Our ref: AN/2009/106935/05-L01

Date: 25 June 2009

**TWO SINGLE STOREY EXTENSIONS TO EXISTING BUILDING, ERECTION OF
DETACHED PORTACABIN OFFICE AND EXTENSION TO EXISTING CAR PARK.
REVISED FINAL FLOOD RISK ASSESSMENT.
RANGELL GATE, LOW FULNEY, SPALDING, PE12 6EW.**

Office building Plan and Elevations

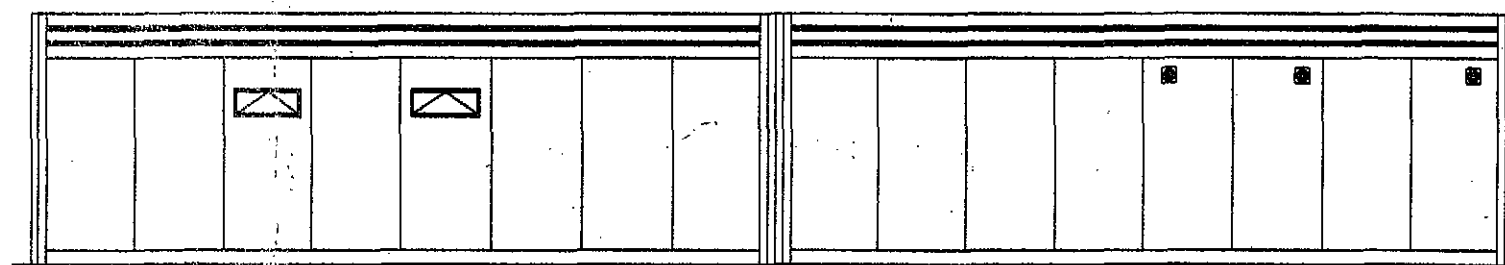
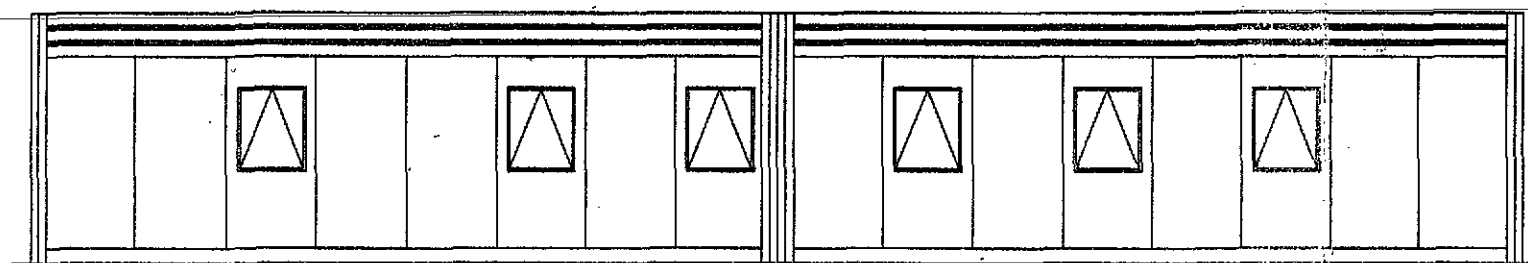
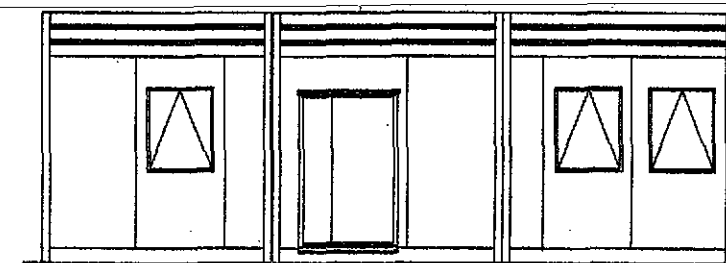
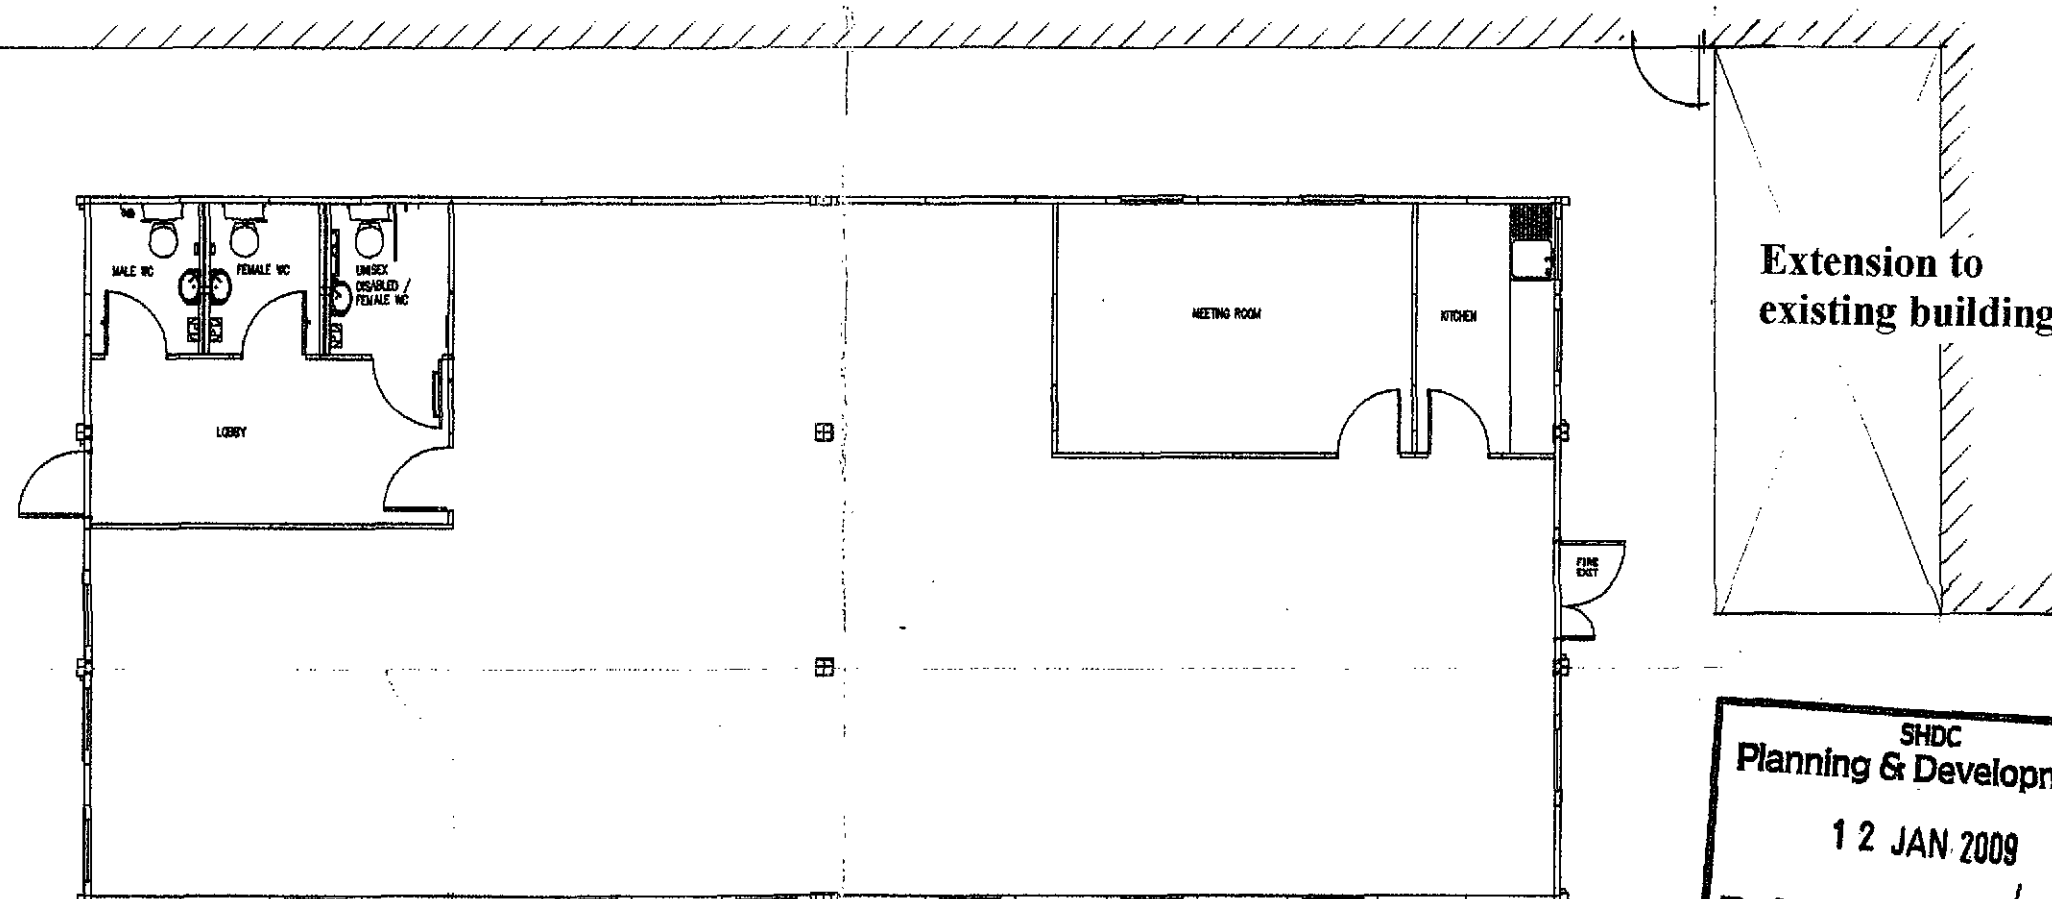
- Finished floor levels for the proposed development will be set no lower than 3.5m AOD
- The proposed portacabin on site will be securely fastened down (for example the use of chains and ground anchors).

The application site lies within Flood Zone 3a defined by Planning Policy Statement 25 (PPS25) as having a high probability of flooding. Although the extensions to the existing buildings have a footprint less than 250 sq metres, a FRA should be submitted to assess the risk to the stand alone Portacabin unit which forms part of the application.
